**Further submissions following Issue Specific Hearings 20<sup>th</sup> January 2021– Snape PC**

**(EN 010077/78) Ref 20023749/50**

Snape PC

A1094/ B1069 WIDENING FOR ABNORMAL INDIVISIBLE LOAD

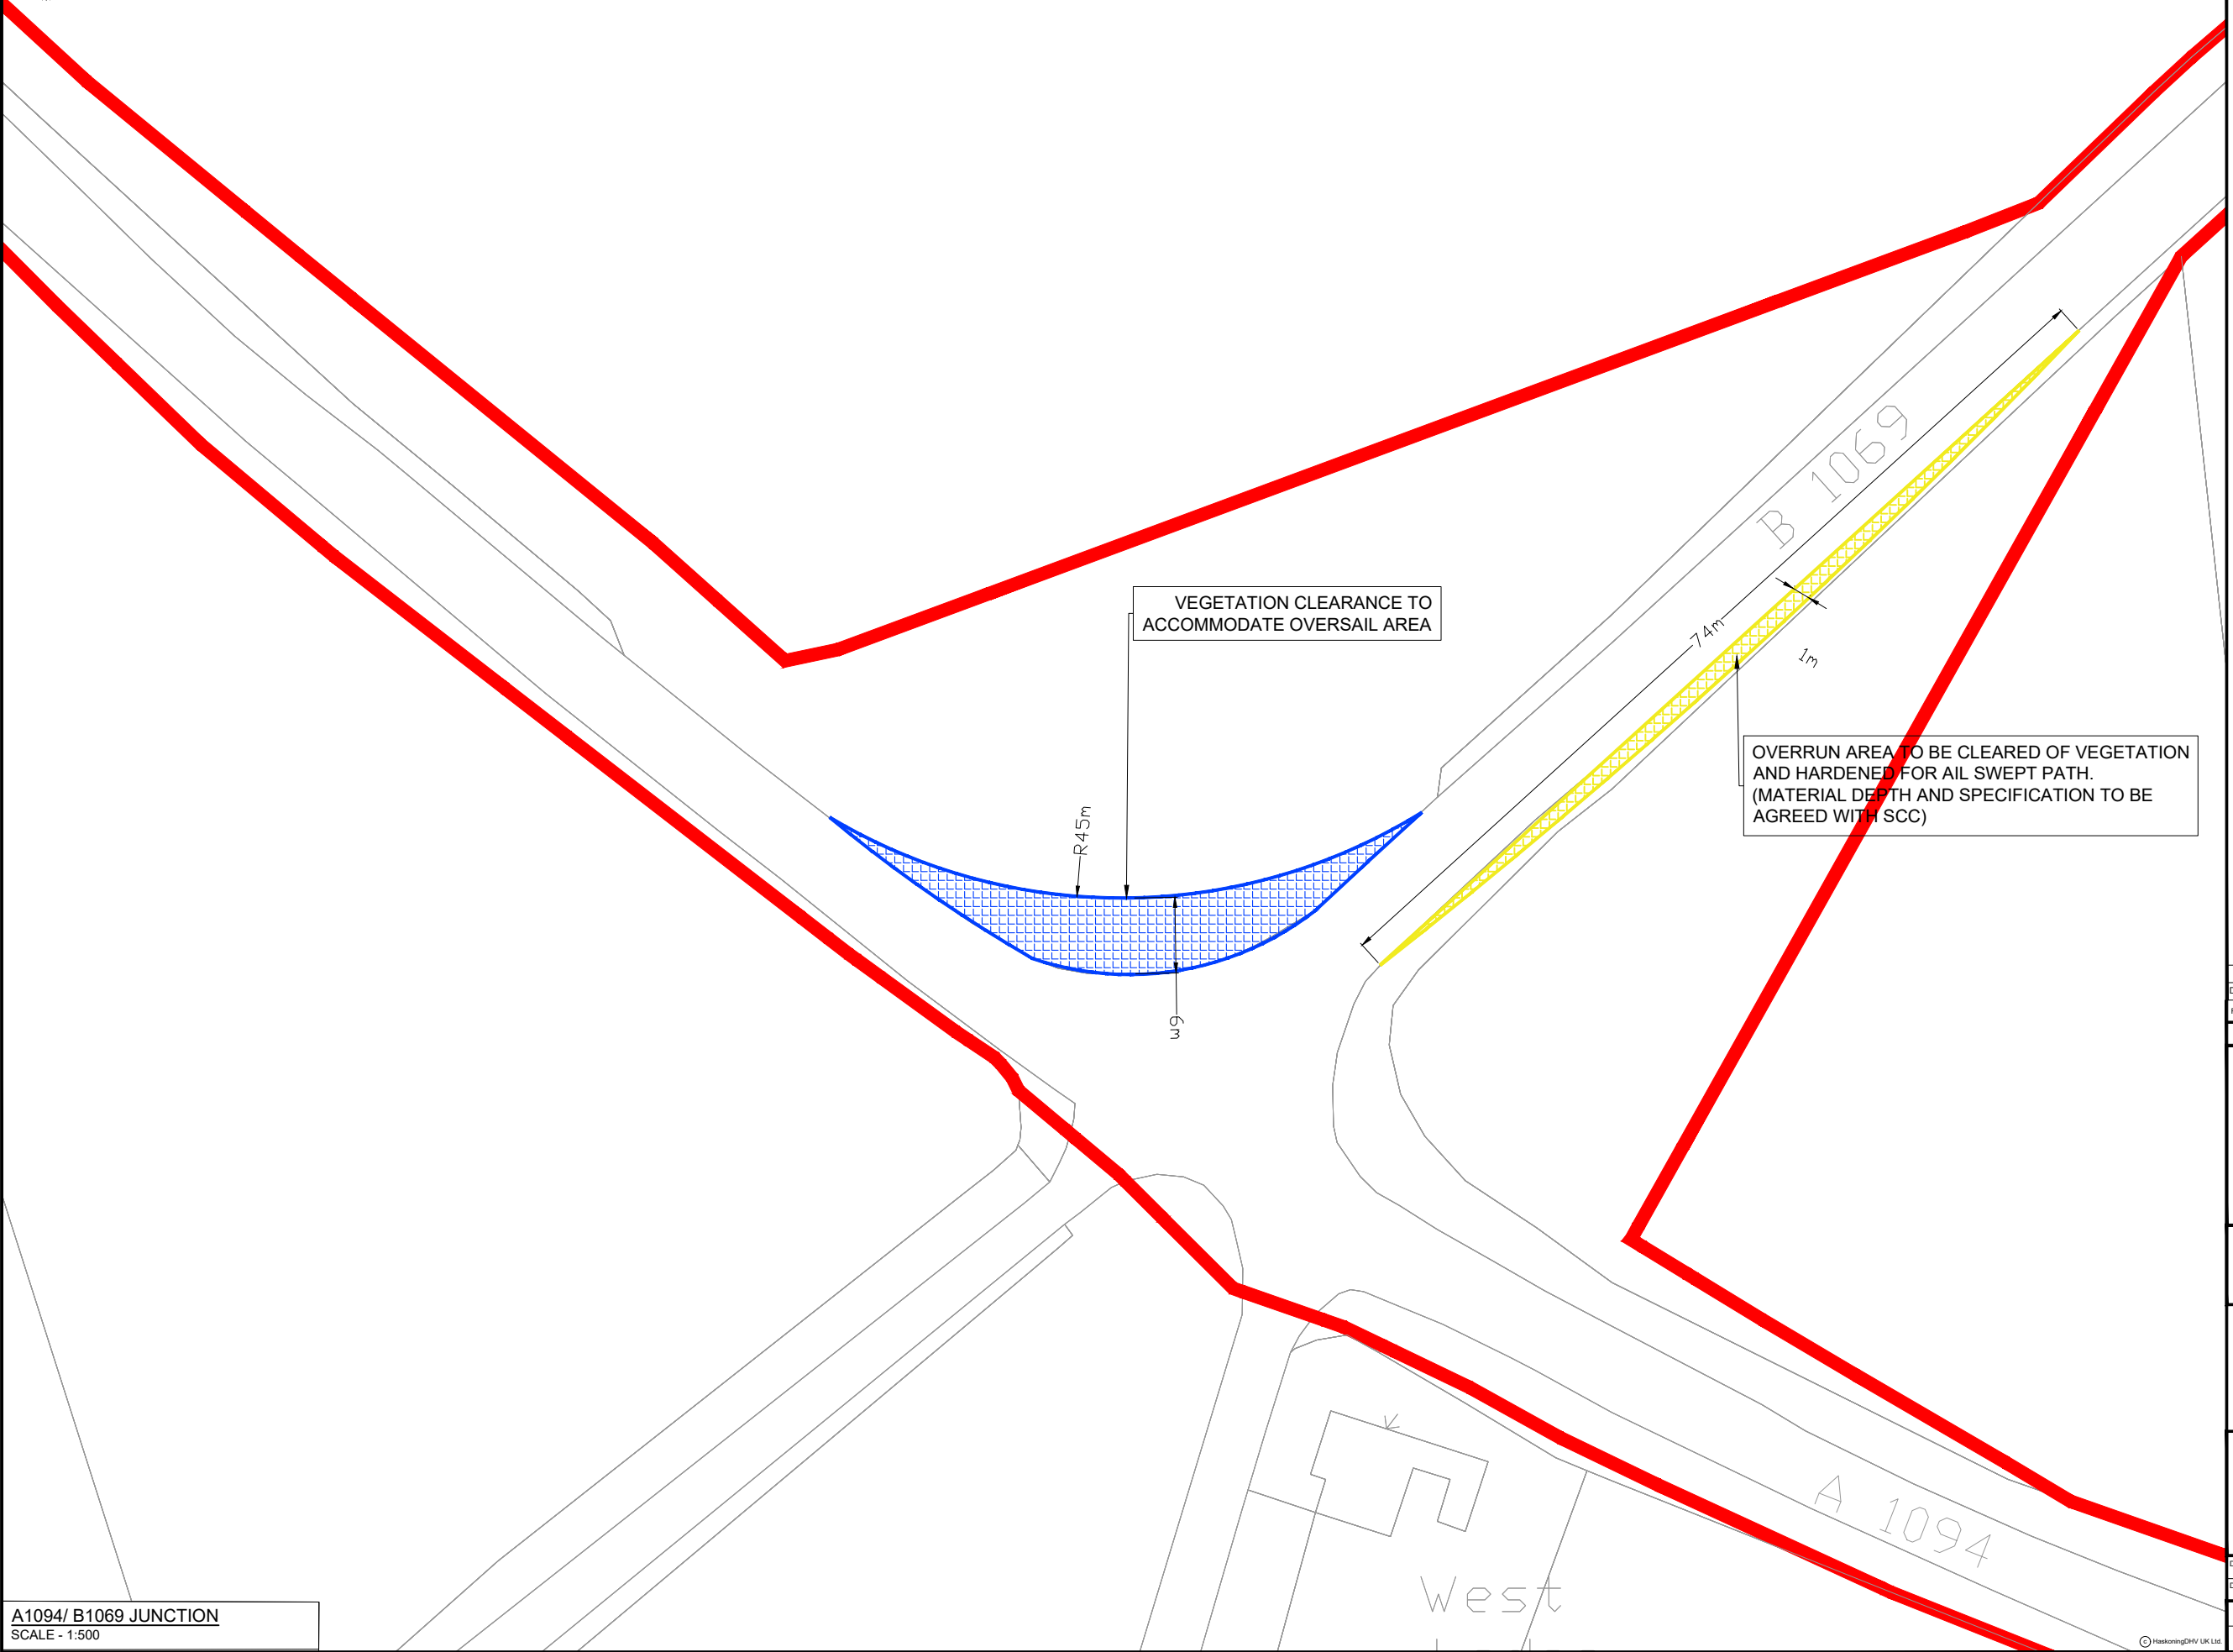
The consultant Mr Ross for SPR dismissed the issues of road width on the A1094 and congestion at the A1094/ B1069 junction by asserting that the A1094 was an approved route for HGVs and that the traffic assessments based on average figures had not identified congestion as an issue. We would submit that from March 2018 onwards we have asked for detailed research and analysis on both issues on the basis that our understanding is that the guidance on traffic analysis should where necessary reflect site specific issues and we submit that has simply not taken place. Similarly the assertion that because the A1094 (and the B1069) are approved routes fails to reflect our direct experience and arguably that designation is in fact more about necessity than design and capacity. Suffolk is singularly badly served in terms of the capacity of the road infrastructure and this point still has not been properly addressed SPR within the DCO and the hearings and responses.
